Written Submissions of Oral Case made at Compulsory Acquisition Hearing - 10th December 2020

I & A Simkin

Drawing Title
**LAND PLANS
REGULATION 5(2)(i)
SHEET 6 OF 10**

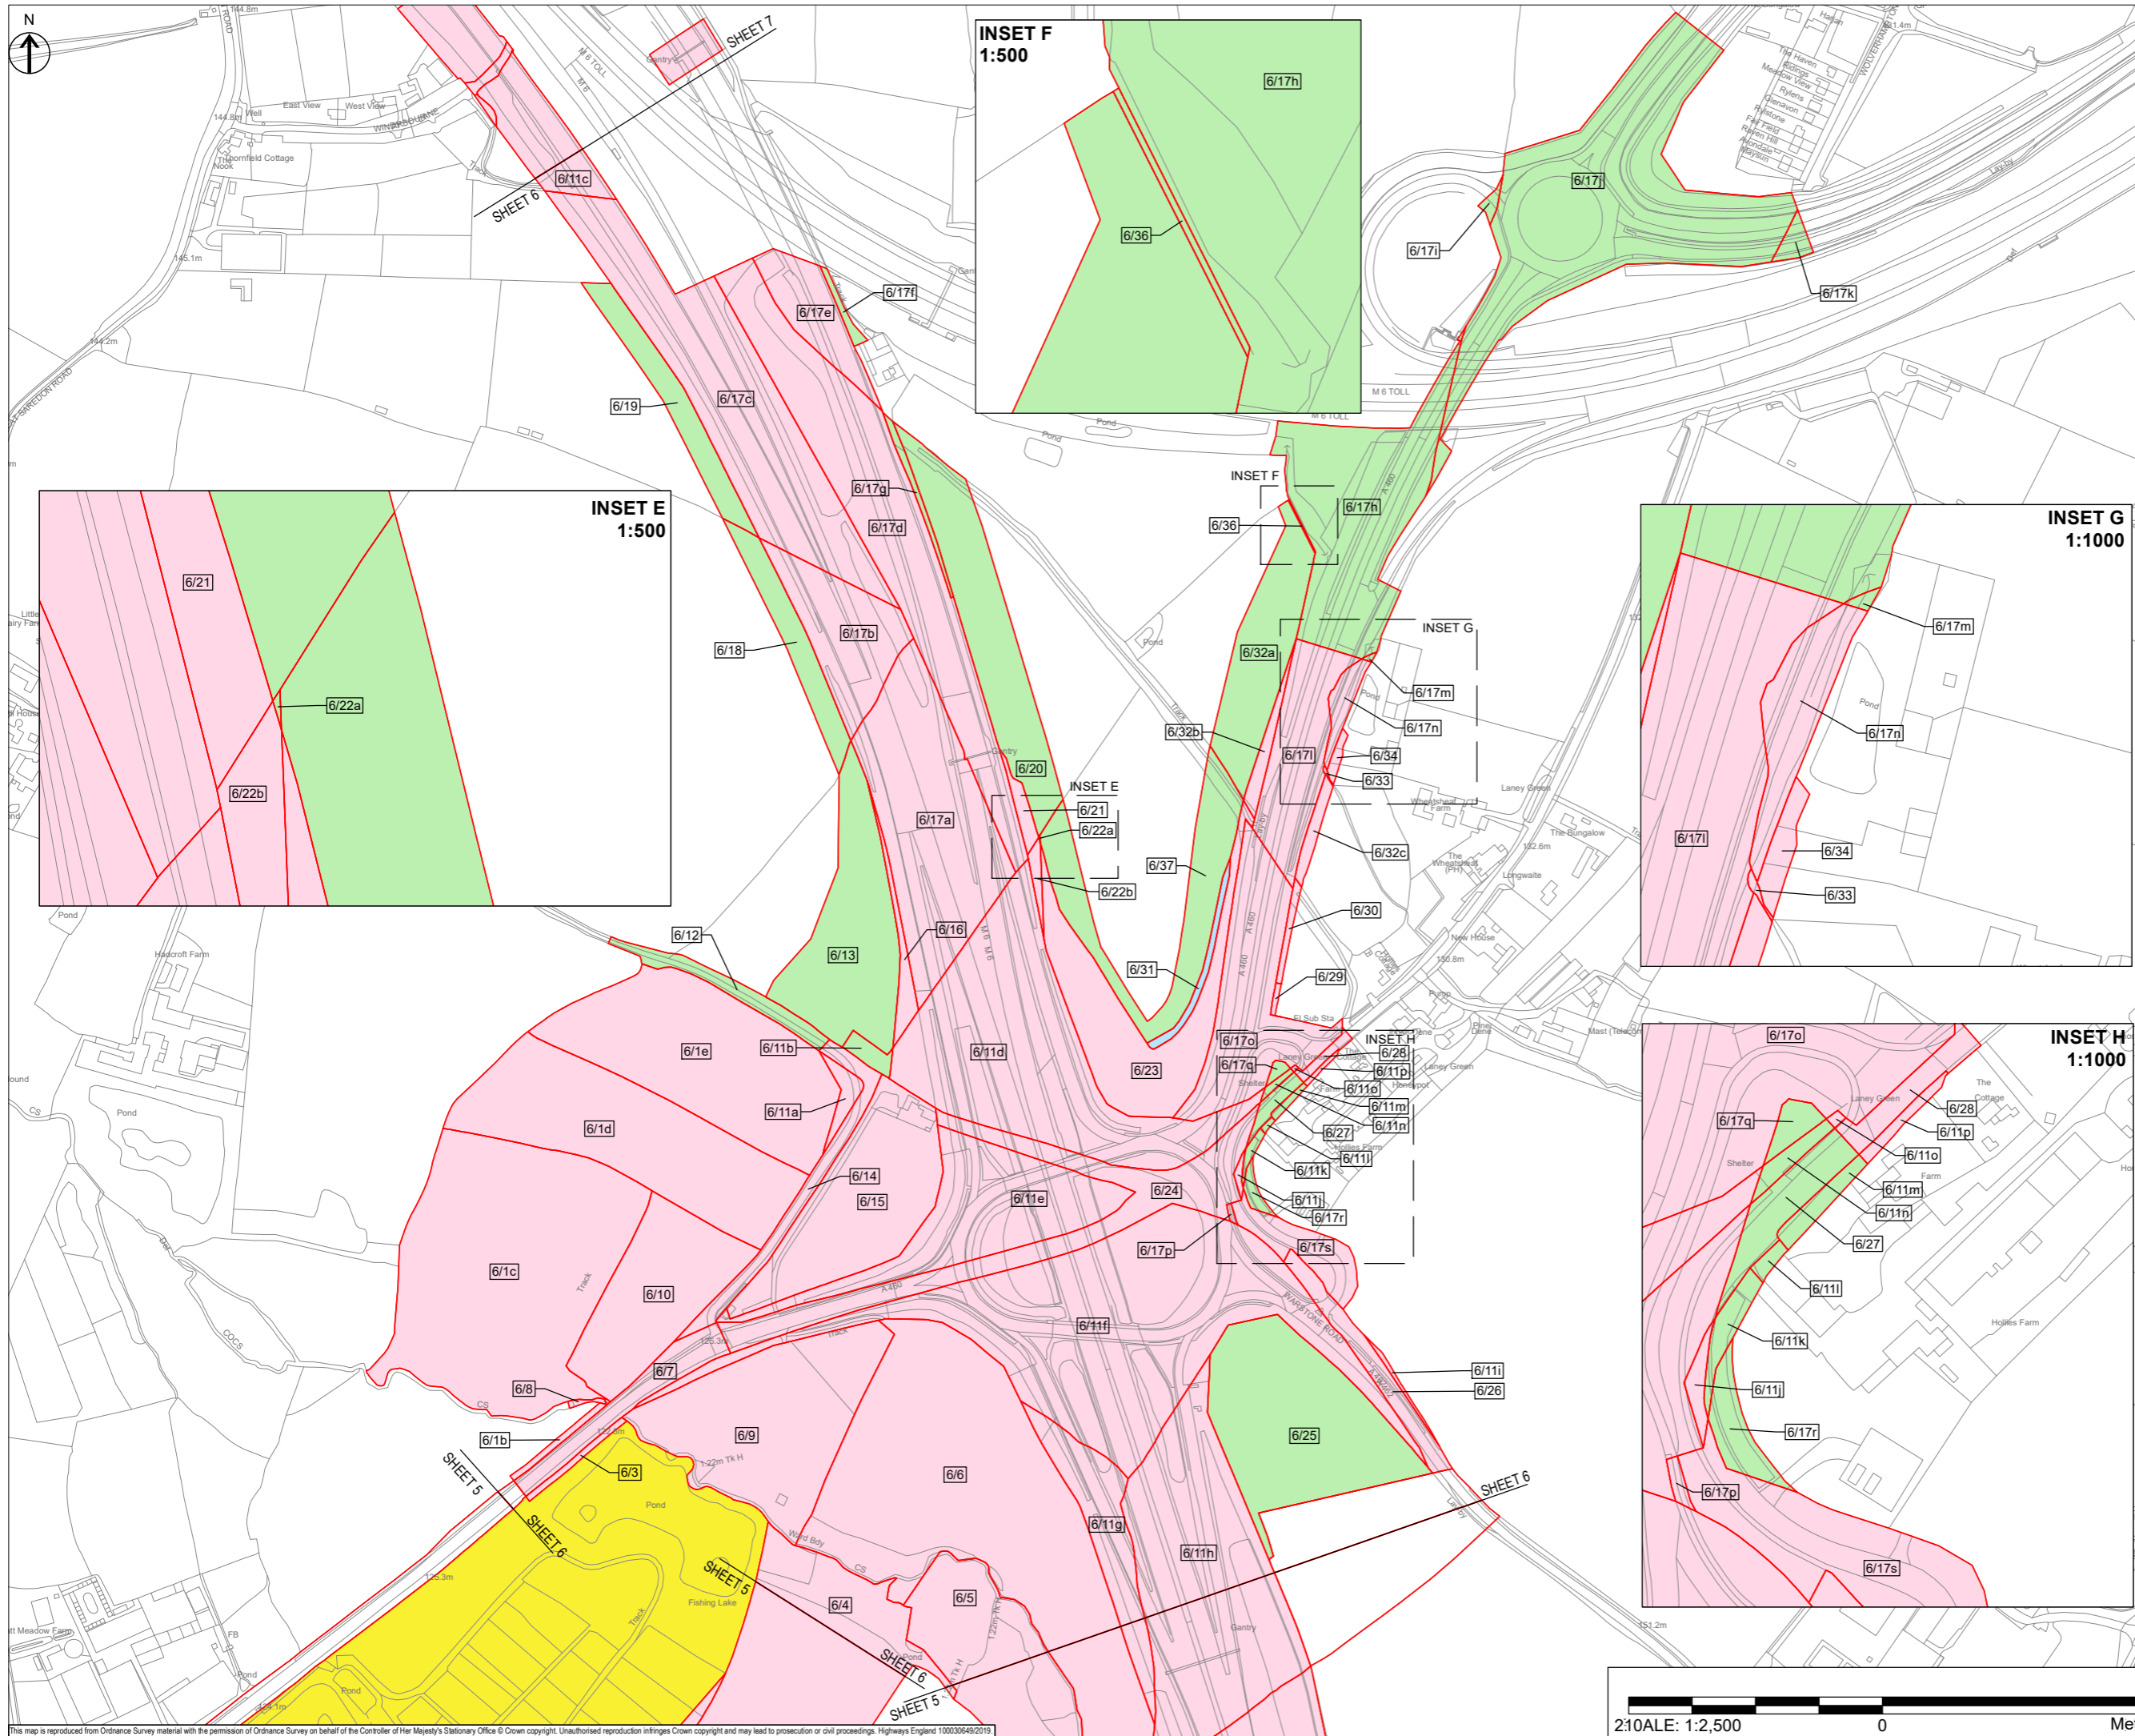
1. The primary issue is in relation to plot 6/25 which is situated to the south east side of Junction 11. There is a significant disparity between the Land Plans 2.2 (Sheet 6) (AS-065) and the Environmental masterplan (sheet1), both as revised in the Formal Scheme Changes. The revised Land Plan shows the entirety of the client's land ownership of plot 6/25 to be used temporarily only. It is however evident that in fact a significant area of plot 6/25 is required by Highways on a permanent basis for the construction of the southbound M6 slip road. We have brought this to the attention of the Applicant who have since confirmed verbally that their Land Plans are incorrect. We request clarity on the extent of land over which permanent compulsory acquisition is sought and the area over which temporary rights are sought. The Applicant has not met the requirement to provide clear plans to of the land over which compulsory acquisition is sought. We have received communication from the Applicant in relation to arranging discussions to address this matter.

2. In our submission to the Examining Authority on the Accepted Changes, we welcomed the removal of Environmental Mitigation, in the form of species-rich grassland, over what we believed to be the *entirety* of the field at this location, however it is now evident from the revised Environmental masterplan that there may be areas of my client's land where compulsory acquisition is sought by the Applicant for mitigation grassland, in addition to the areas for construction works.

4. The strips of grassland are, in the main, situated away from the new roadways and at the base of embankments on the perimeter of the retained farmland. I would put to the inspectors that the Applicant has not evidenced that the acquisition of the grassland strips are necessary for the development, or, are required to facilitate or be incidental to that development, because the land areas will not serve their primary landscaping function as they are positioned where they will not be visible from the road schemes or to anyone other than my client when farming the fields.

5. Furthermore, the land in both plots is good quality arable Land of Classification Grade 3a, which has been highlighted by both the Applicant and Natural England to be Best and Most Versatile land (BMV). The compulsory acquisition of the proposed grass strips increases the loss of productive land from what will already be significantly reduced field size which will then become less viable for arable cropping (due to the large equipment that is used).

6. The loss of agricultural land is contrary to scheme guidelines and we have offered alternative less productive land nearby owned by my client for environmental mitigation if required. The Applicant is required to assess the alternatives and we have no evidence to suggest that they have done so.

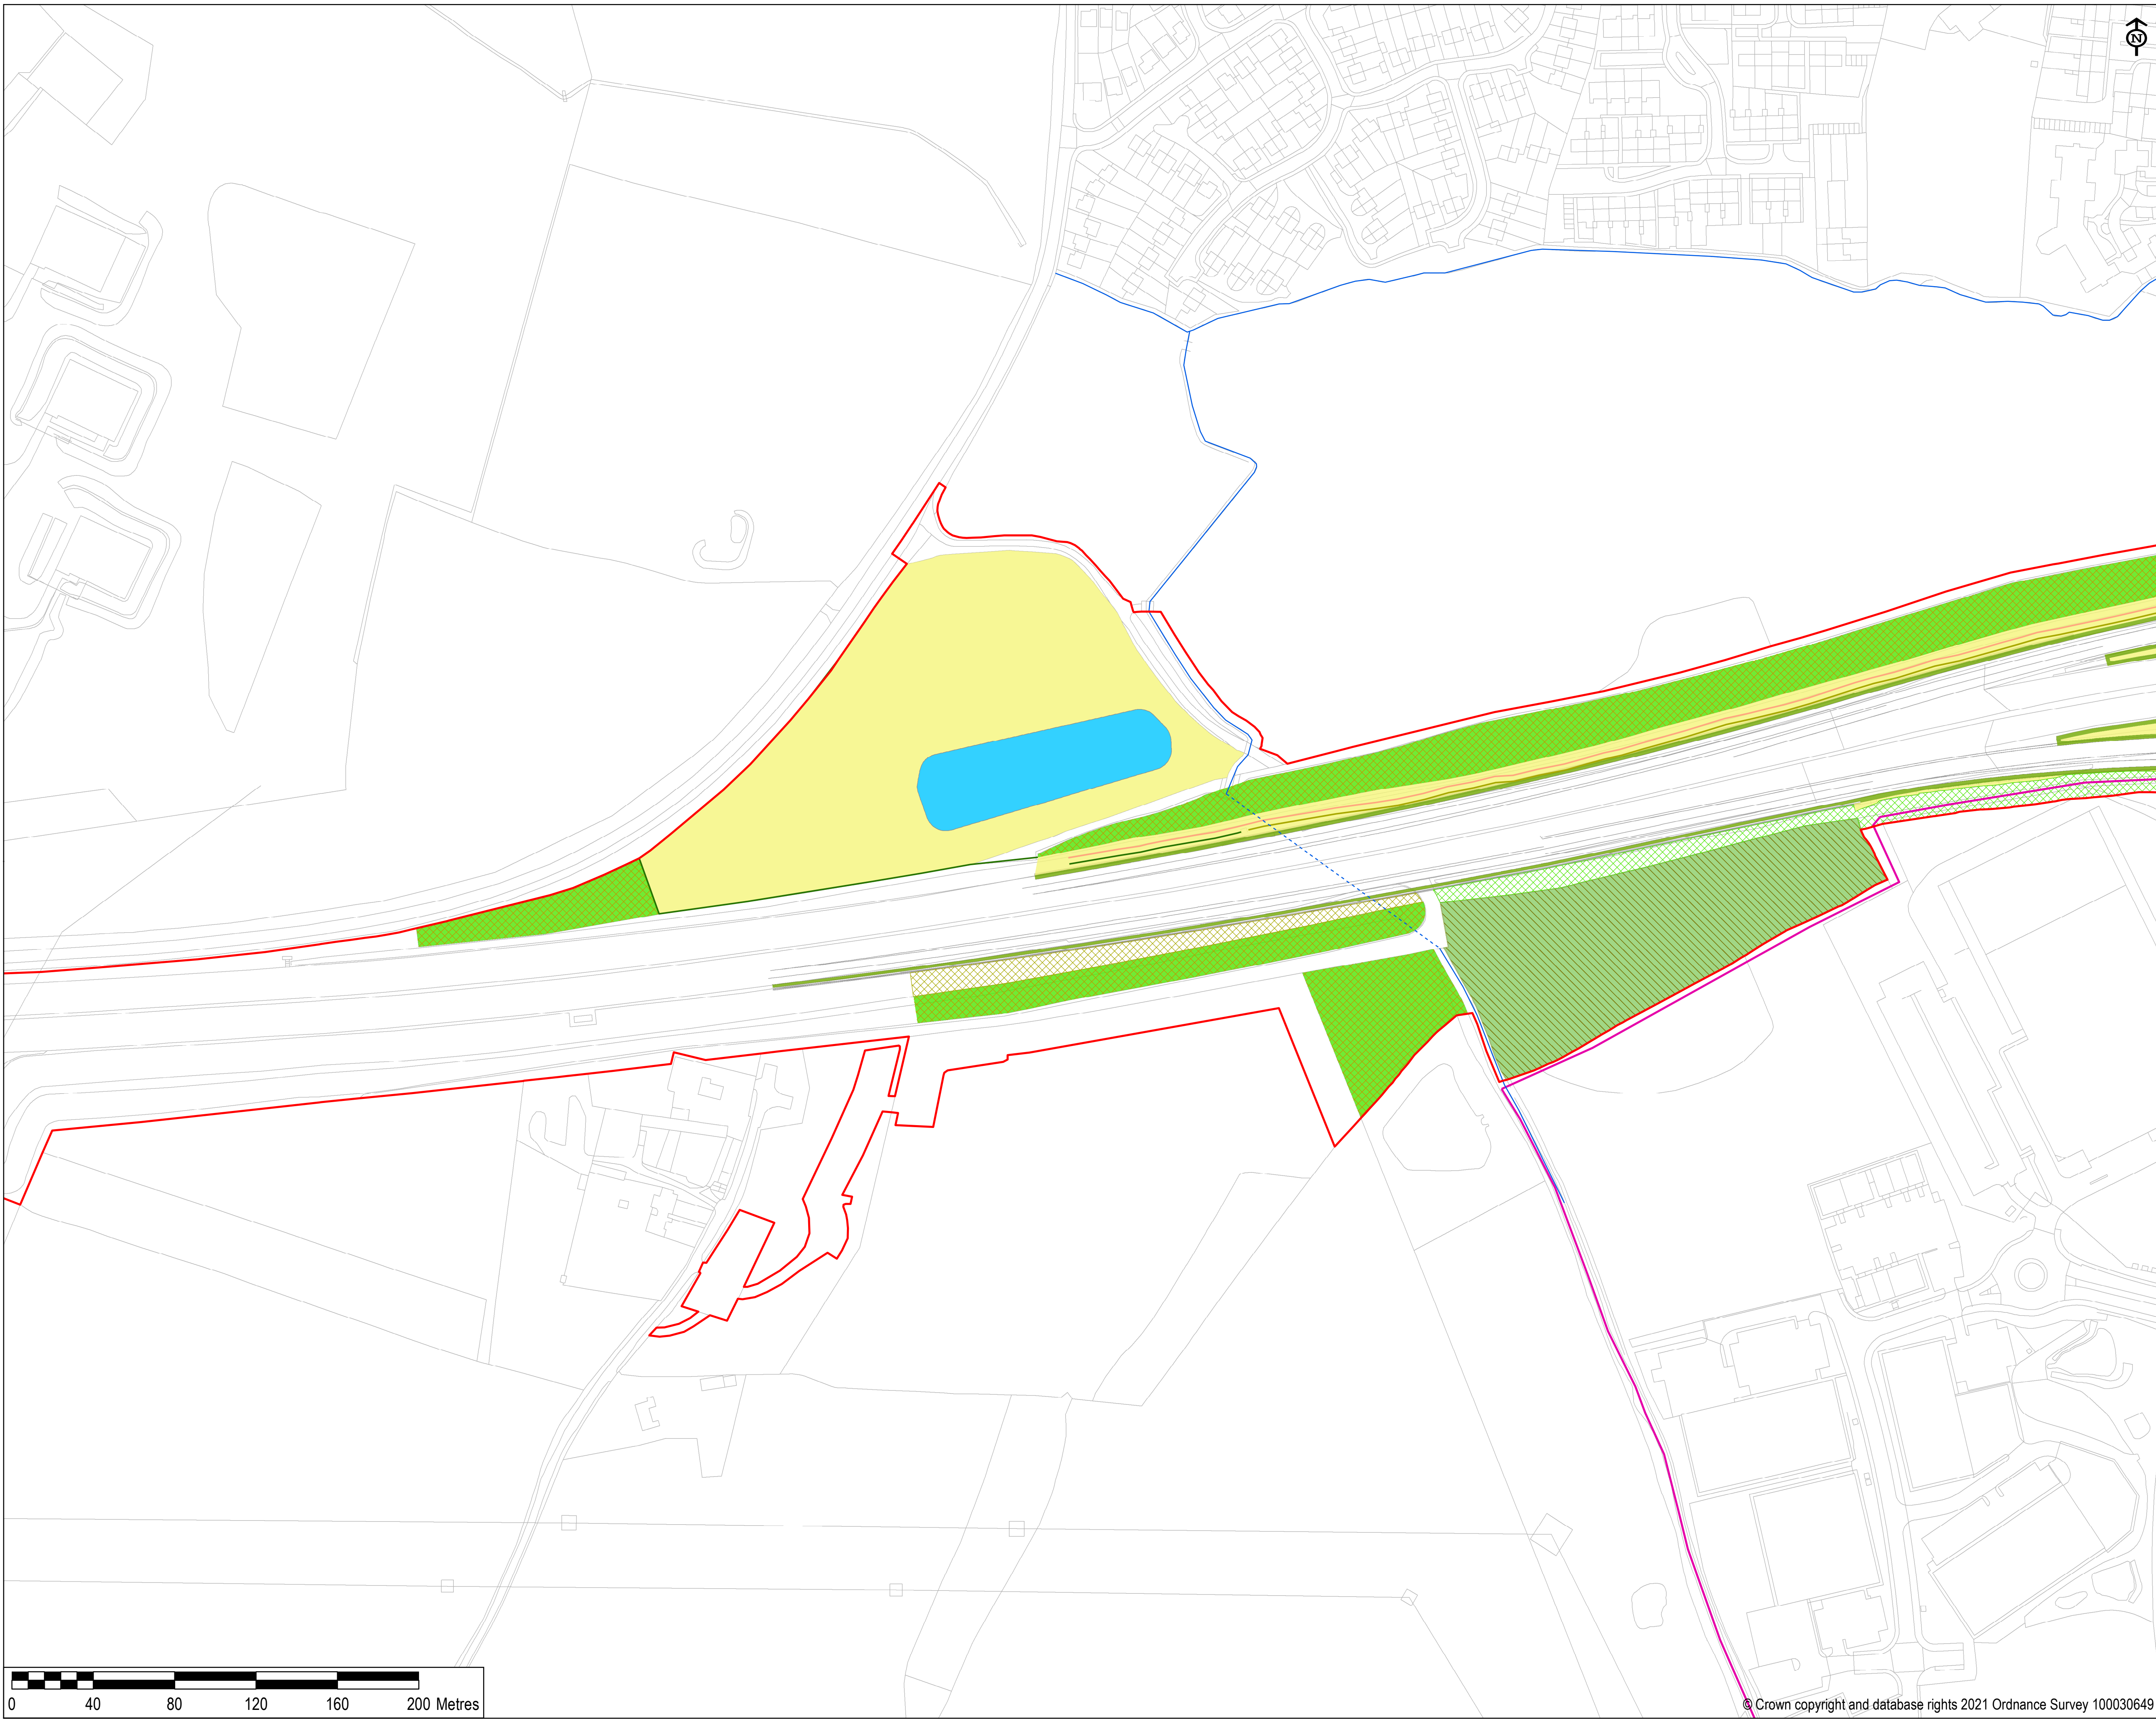
3. The Permanent acquisition of such strips of land are proposed alongside the construction works in plot 6/23, situated to the north of Junction 11, and on the environmental masterplan on plot 6/25. The reasoning provided in the Environmental Mitigation Approach is that the species rich grassland is located along the new verges and embankments for visual amenity and safety reasons, with biodiversity benefits being of secondary importance.
